MP09_0187 – MIX USE BUILDING AT 6-16 ATCHISON STREET, ST LEONARDS

I refer to the Department of Planning's (DoP) letter dated 27 September 2010 (DoP Reference No: MP09_0187) with regard to the abovementioned Development Application (DA), which was referred to the Roads and Traffic Authority (RTA) for comment under Part 3A of the *Environmental Planning and Assessment Act, 1979* and Clause 104 - Column 2 of Schedule 3 of State Environmental Planning Policy (Infrastructure) 2007.

I wish to advise that the Sydney Regional Development Advisory Committee (SRDAC) considered the traffic impact of this application at its meeting on the 20 October 2010. Below are the Committee's recommendations and RTA's comments on the subject application:

**Basement Loading Dock B1**

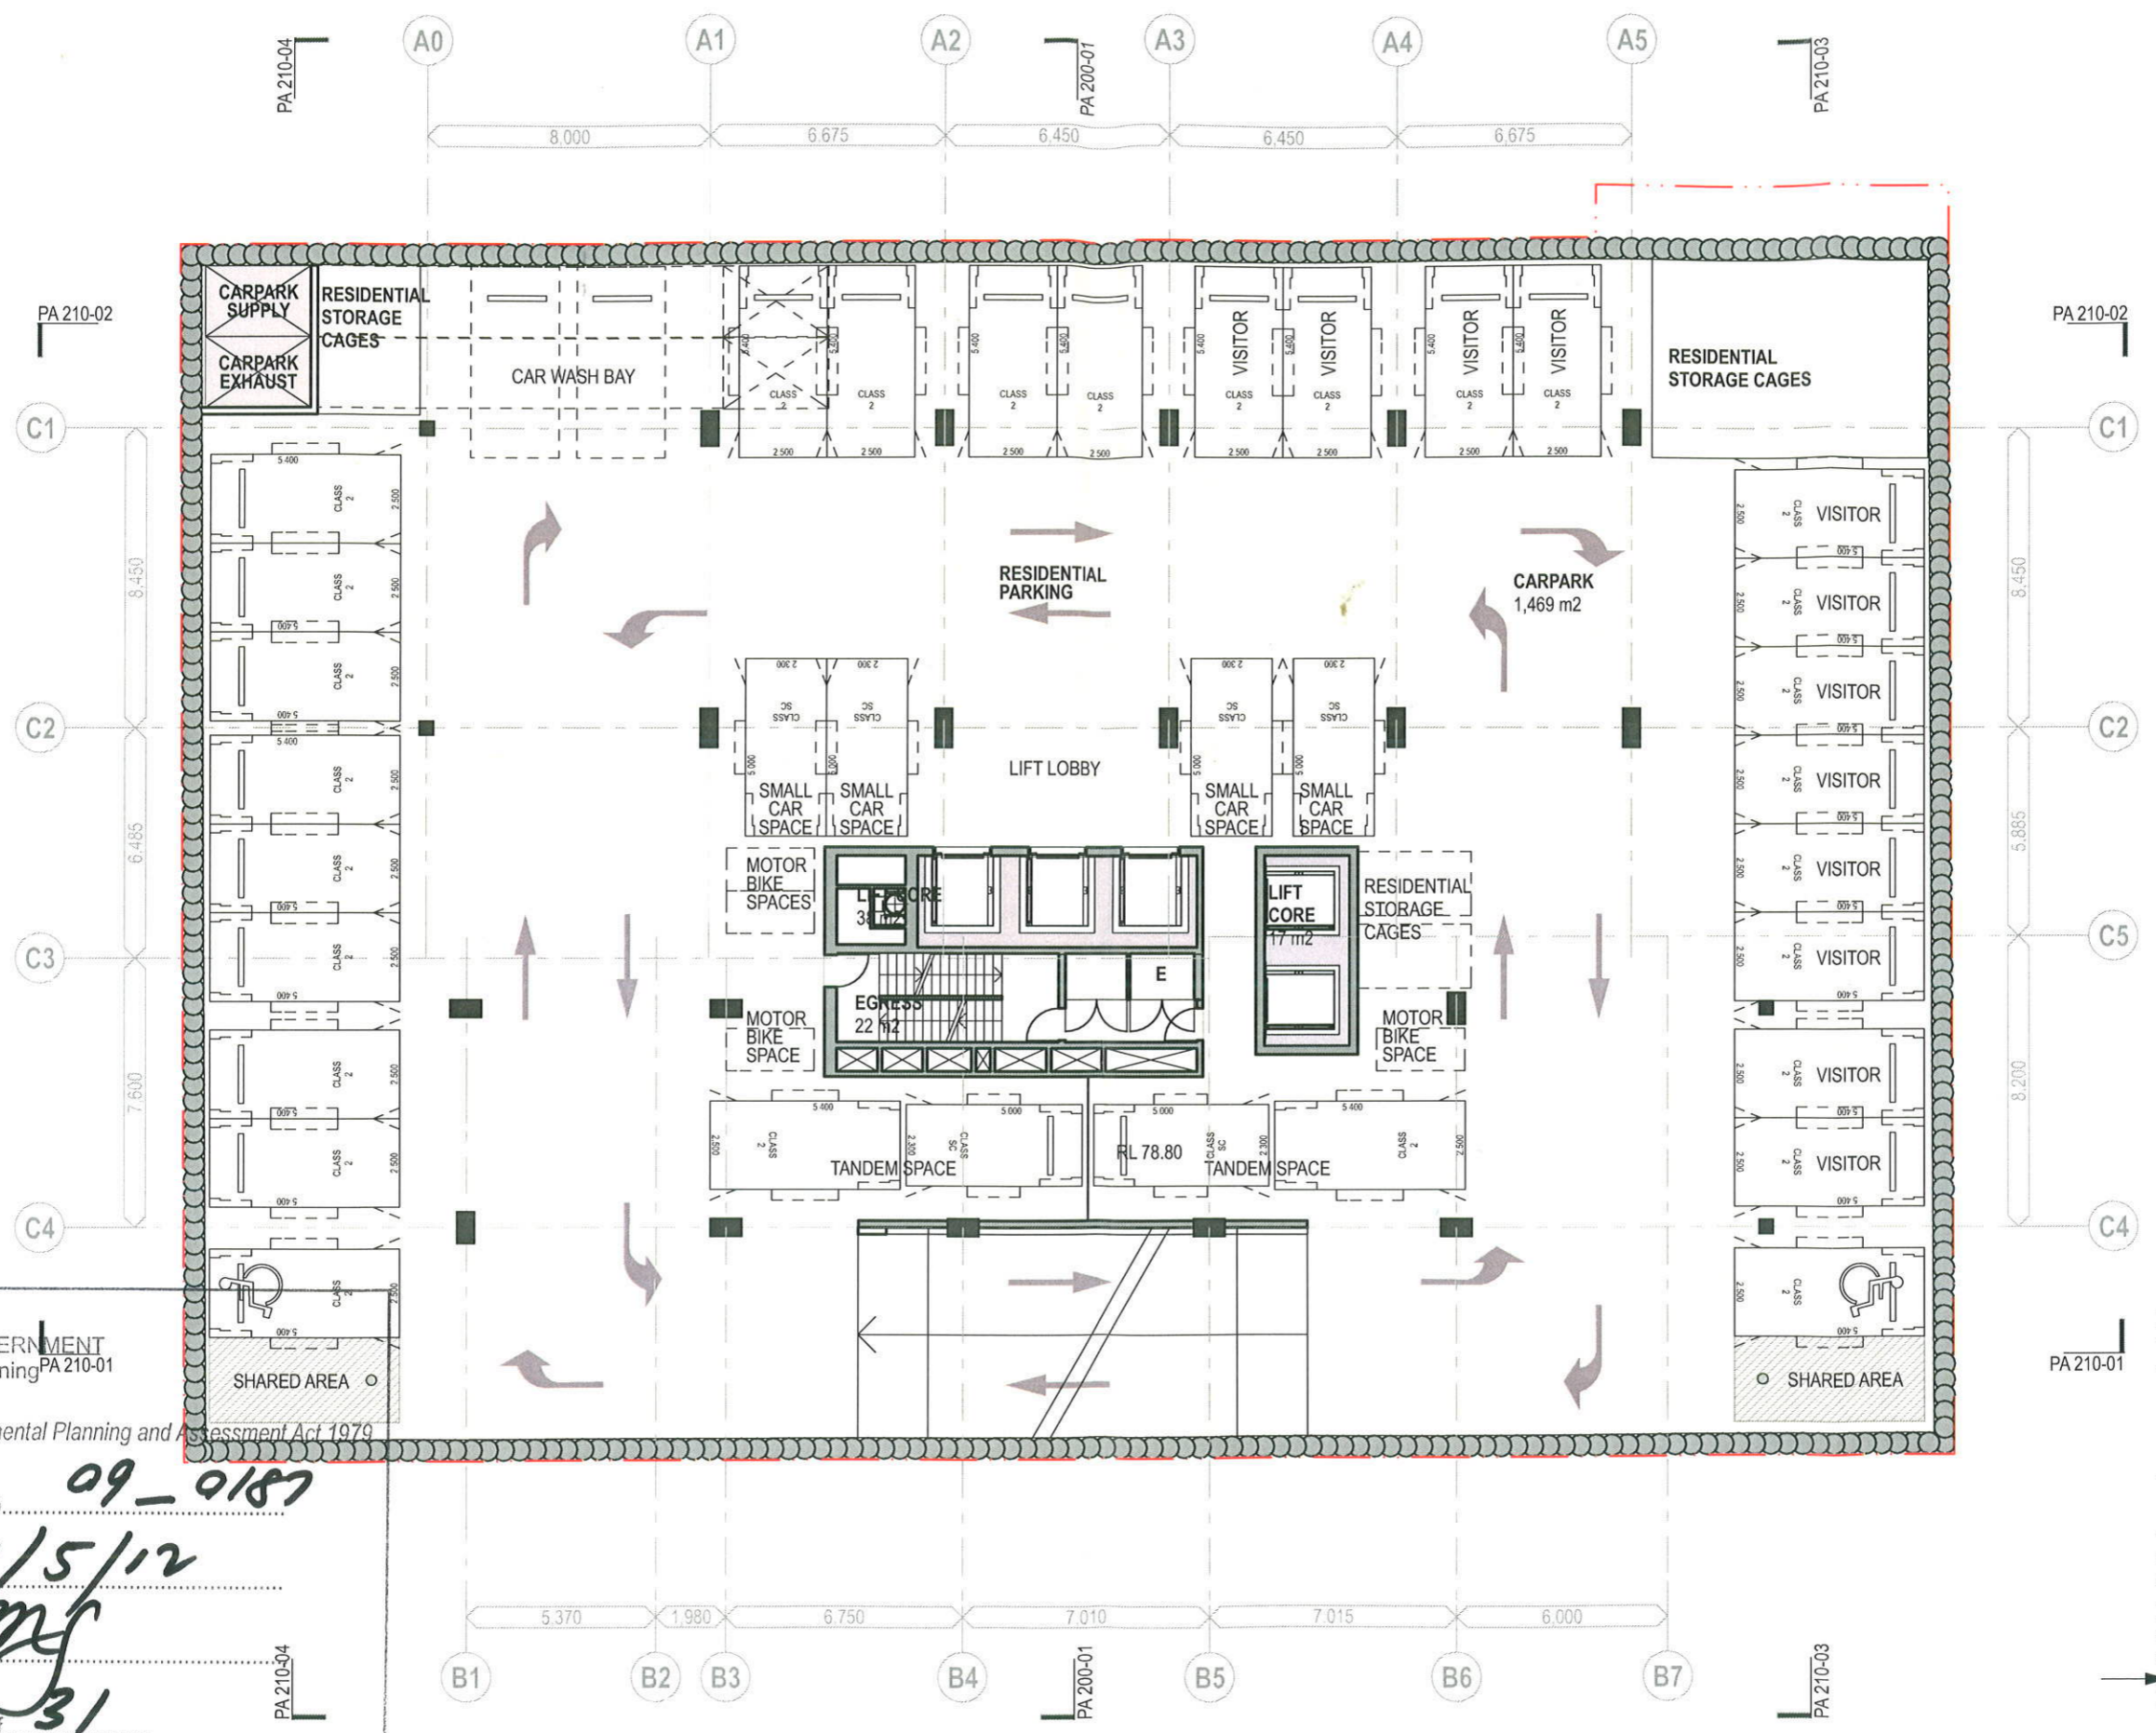
5. All vehicles shall enter and exit the site in a forward direction.
6. Off-street car parking spaces, bicycle facilities and loading docks shall be provided to the satisfaction of Council.
7. The layout of the proposed car parking areas, loading docks and driveway associated with the subject development (including, grades, turn paths, sight distance requirements, aisle widths, aisle lengths, loading bay dimensions and parking bay dimensions) should be in accordance with AS2890.1- 2004 and AS2890.2 – 2002 for large vehicles.
8. A Demolition and Construction Traffic Management Plan detailing construction vehicle routes, number of trucks, hours of operation, access arrangements and traffic control should be submitted to Council, for approval, prior to the issue of a construction certificate.
9. All costs associated with the proposed development shall be at not cost to the RTA.

Scale : A1 1:100	Drawn EN	Authorised
Job No 091602	Drawing No SKC102	Revision P1
Plot File Created: Apr 05, 2011 - 5:19pm

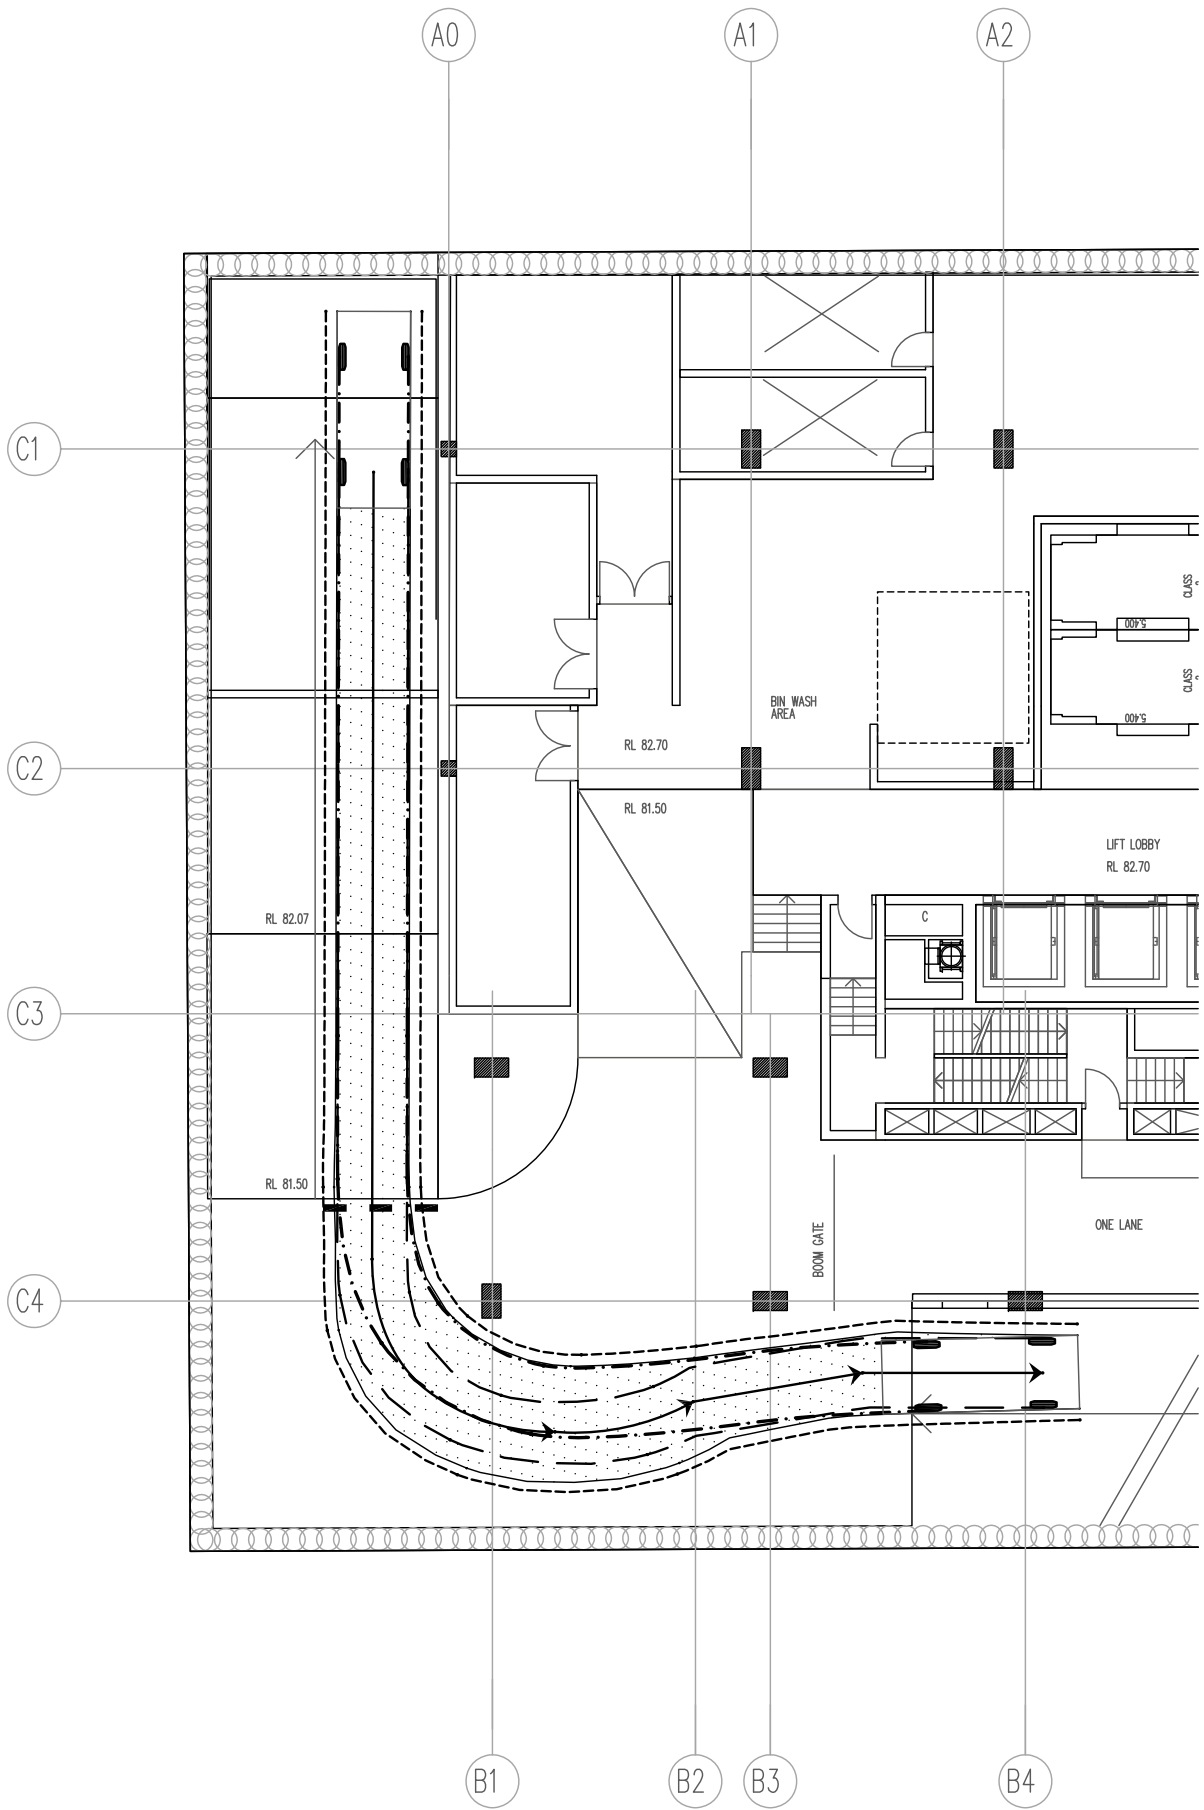
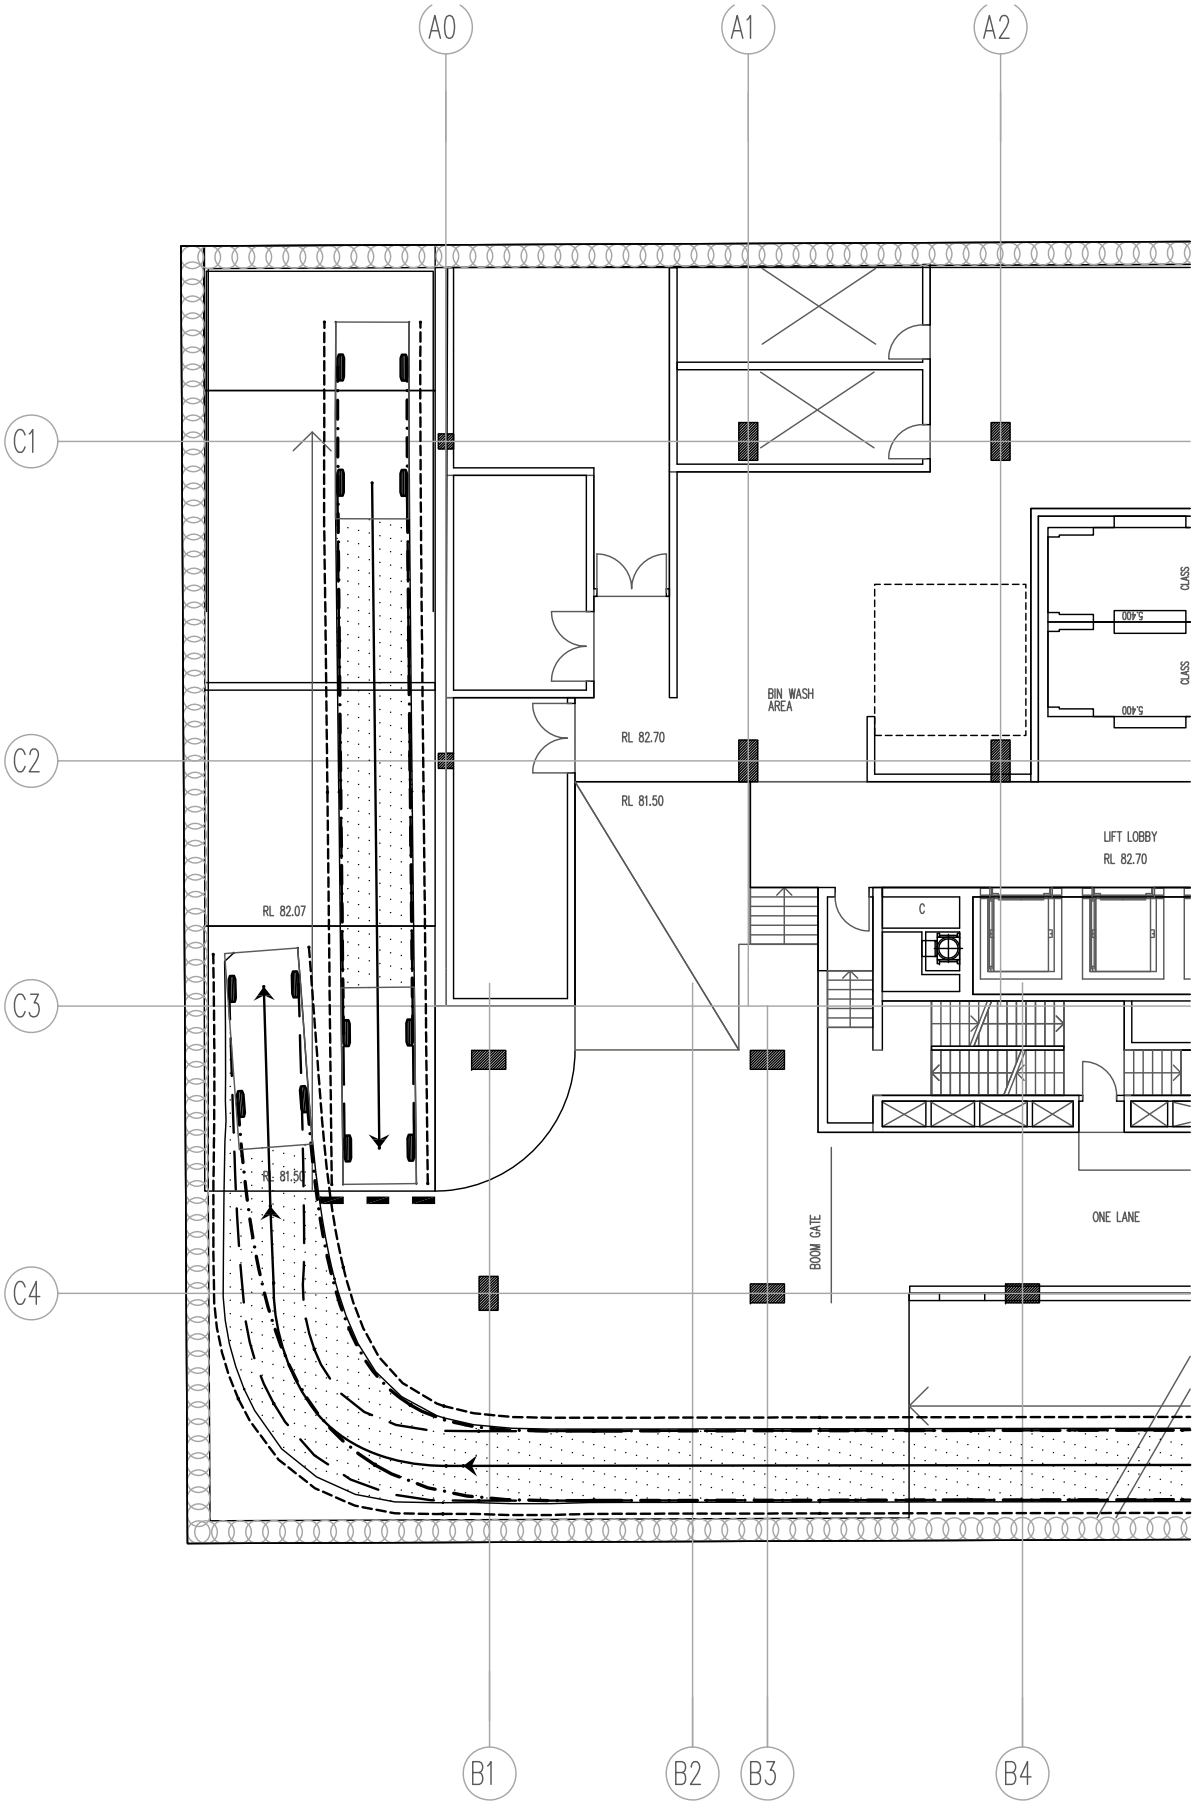
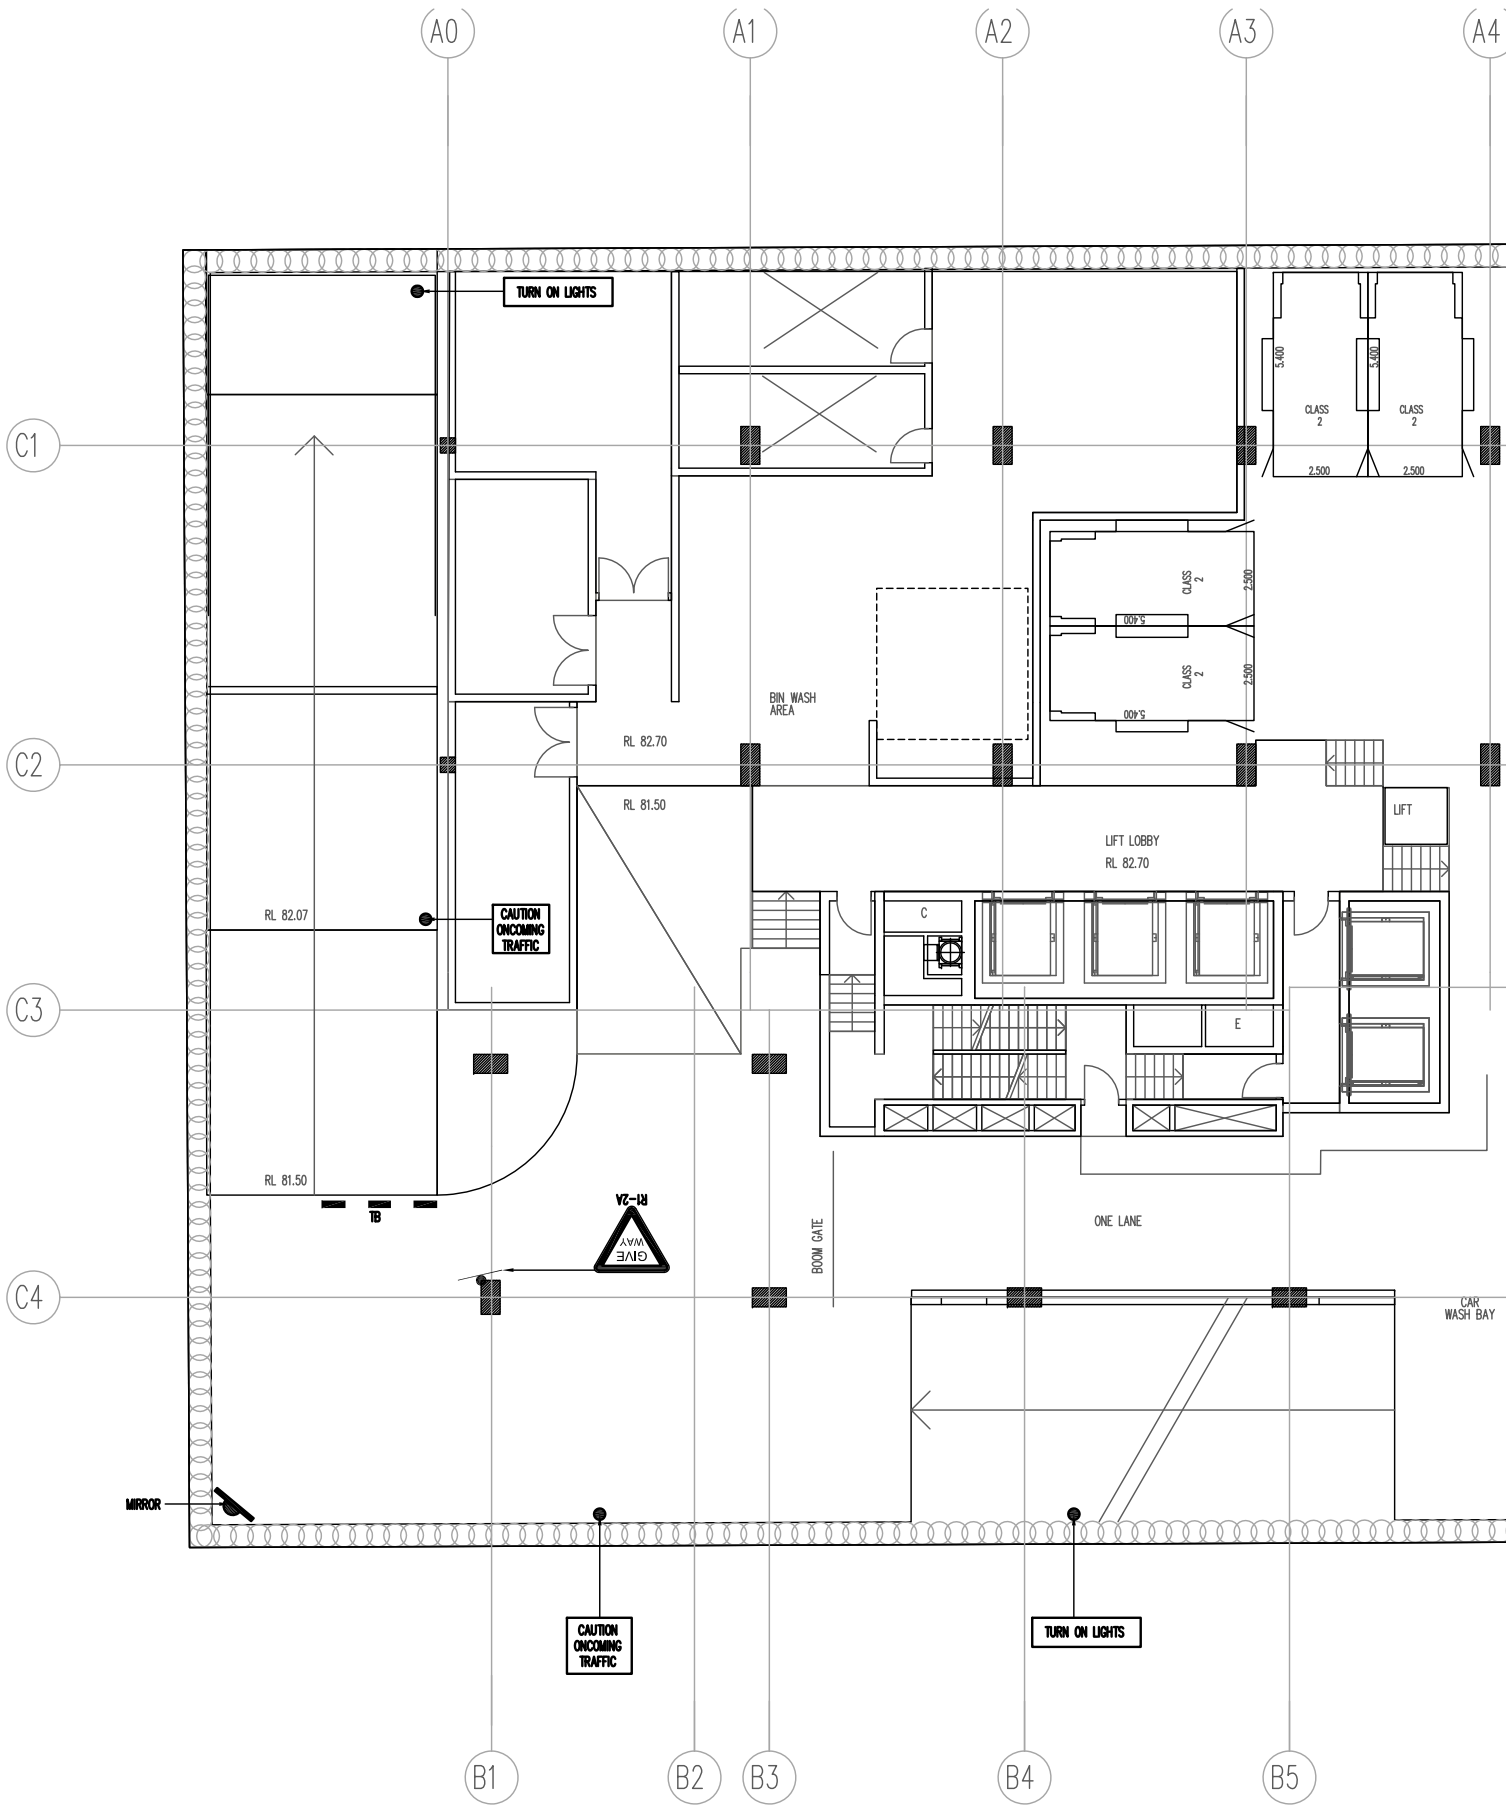
2. Swept path analysis to the satisfaction of DoP and Council shall be provided that the largest vehicle (i.e. 6.4m small rigid vehicle) can physically enter and exit Atchison Lane and the access driveway. Additional splays or modification of the kerb alignment may be required on Atchison Lane, connecting streets and on the access driveway.
3. A condition that prohibits trucks longer than a 6.4m small rigid vehicle from entering the site should be included in the DA consent.
4. The residential component of the proposed development should be designed so that road traffic noise from Pacific Highway is mitigated by durable materials and comply with the requirements of Clause 102 – (Impact of road noise or vibration on non-road development) of State Environmental Planning Policy (Infrastructure) 2007.
